From: Bloomer, David [<mailto:David.Bloomer@lancashire.gov.uk>]
Sent: 22 September 2015 08:52
To: John Macholc
Subject: app3/2014/0956 Fairclough House

Comments dated 7/5/2015

Project Details,
PROPOSED SITE PLANS

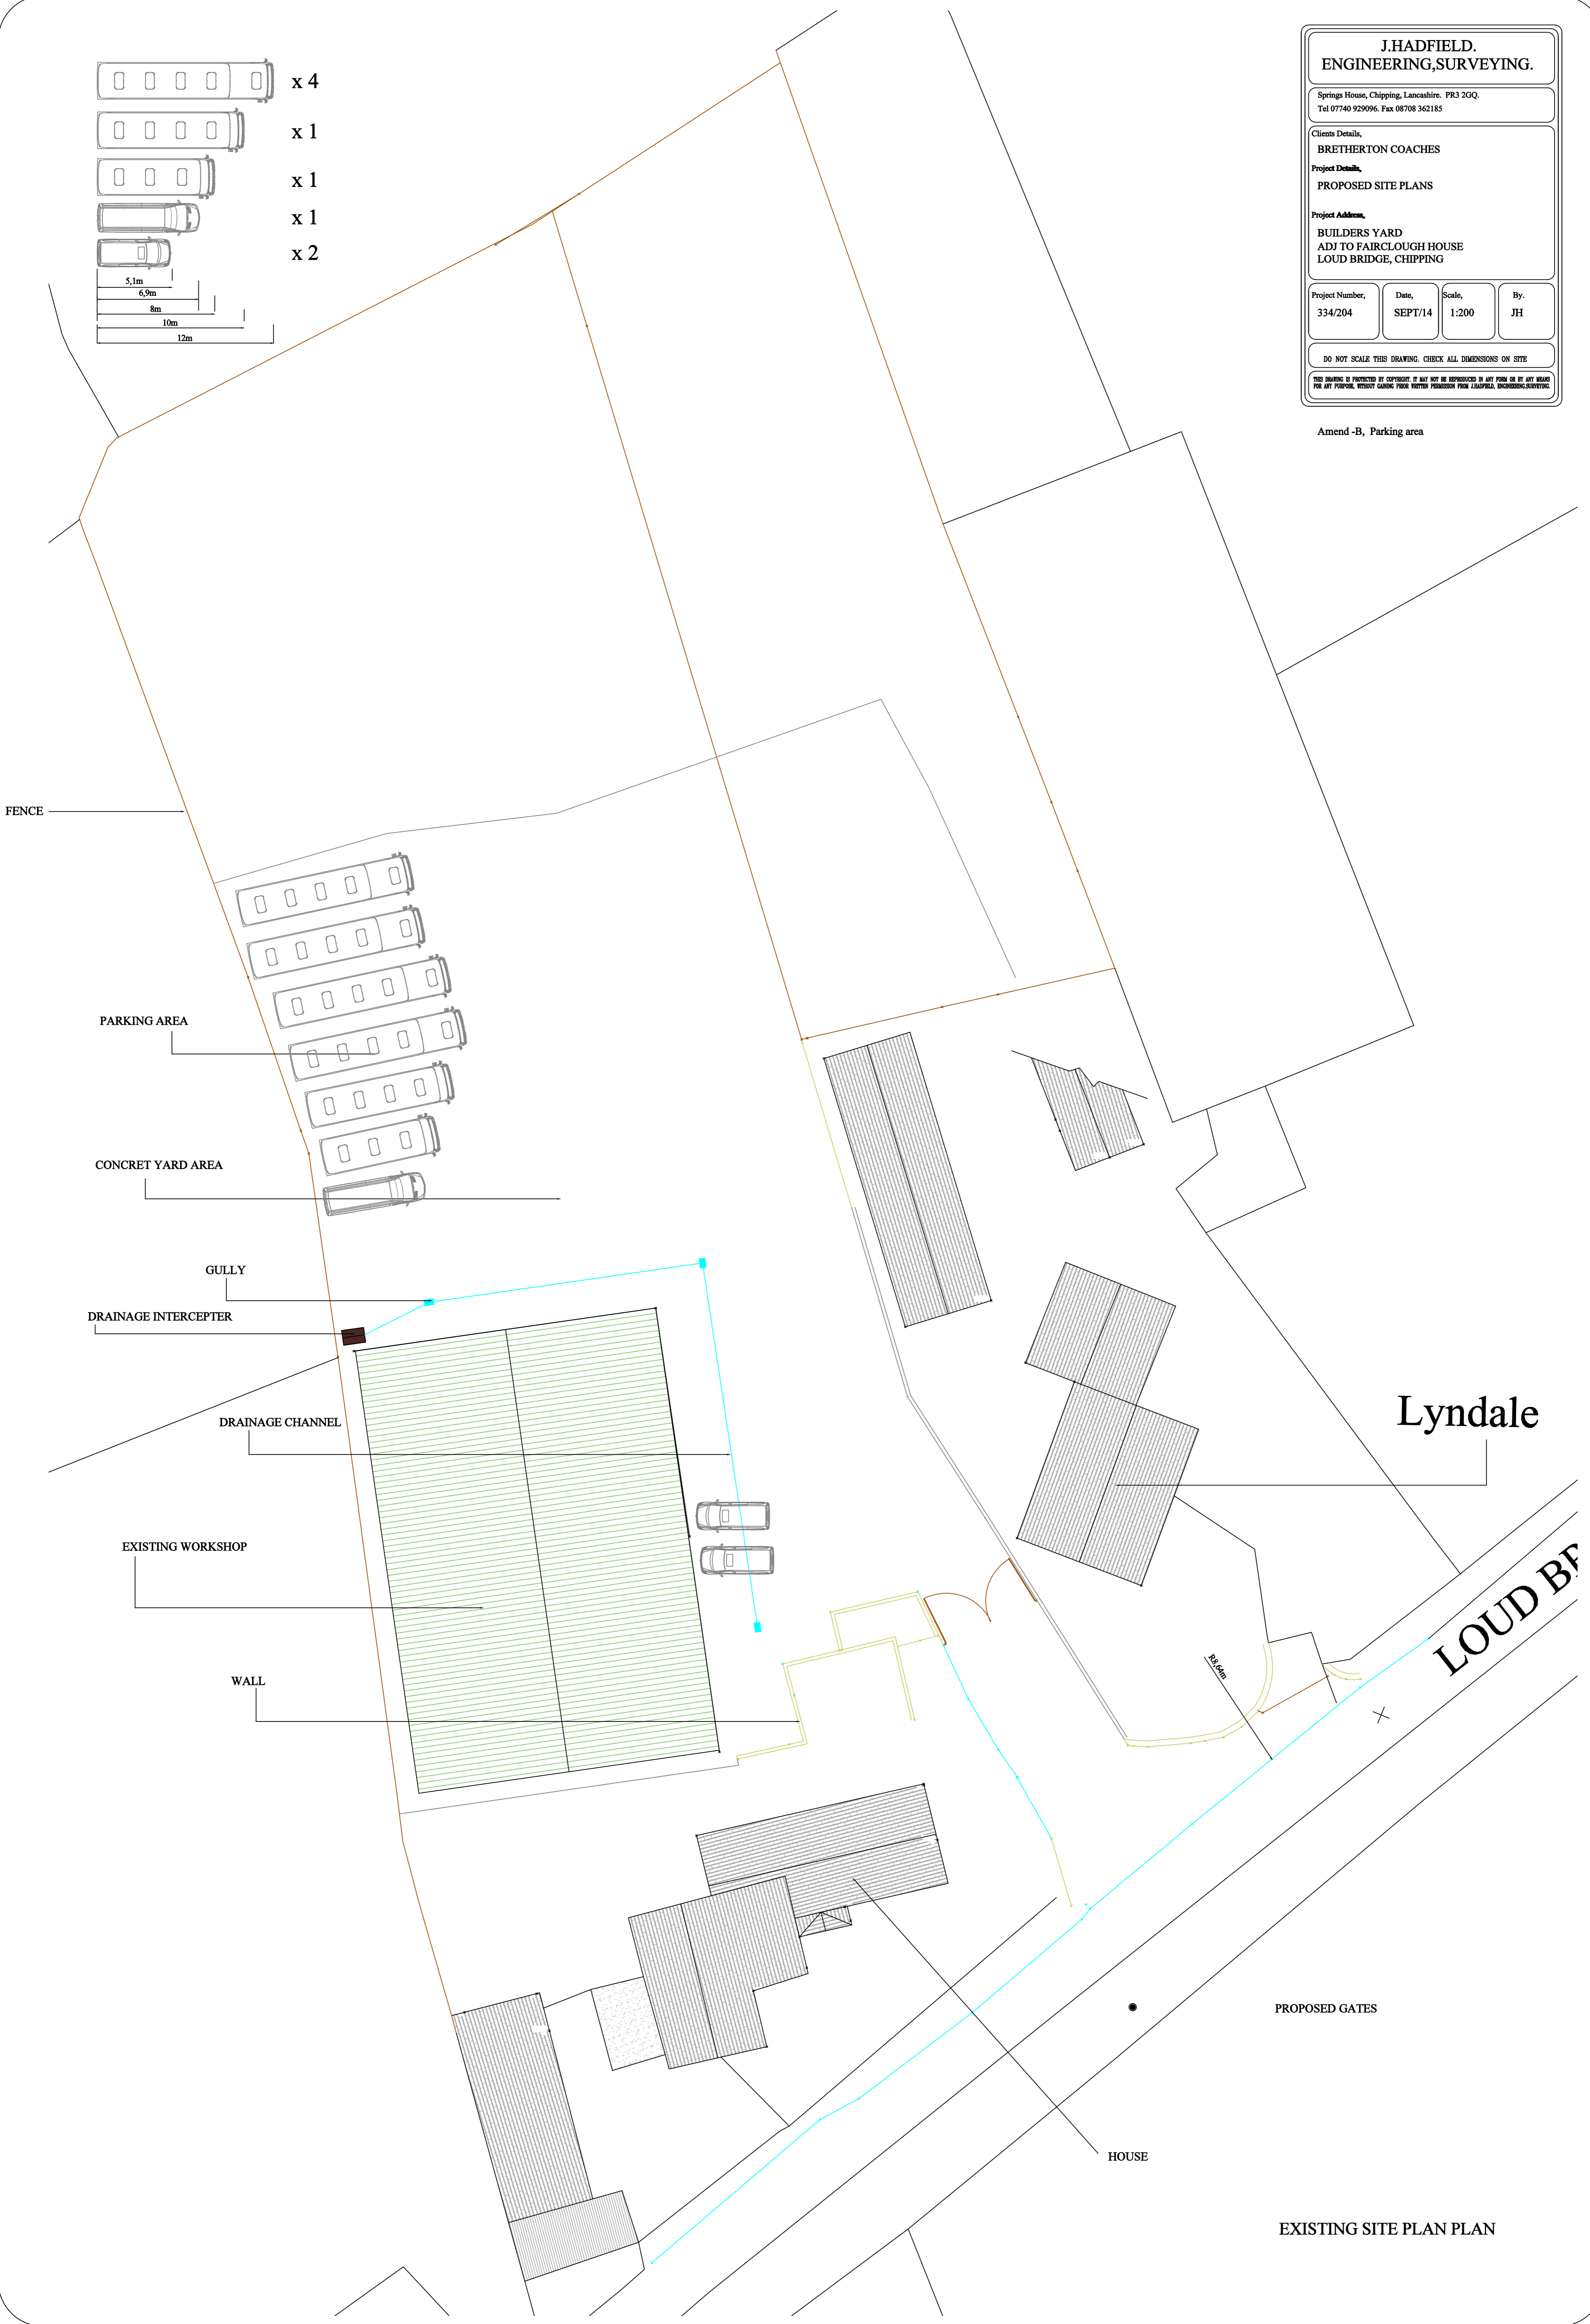
4 The parking shall be in accordance with the parking layout shown on the Parking Area Plan Amendment B submitted 17th April 2015 Reason to ensure efficient use of the site
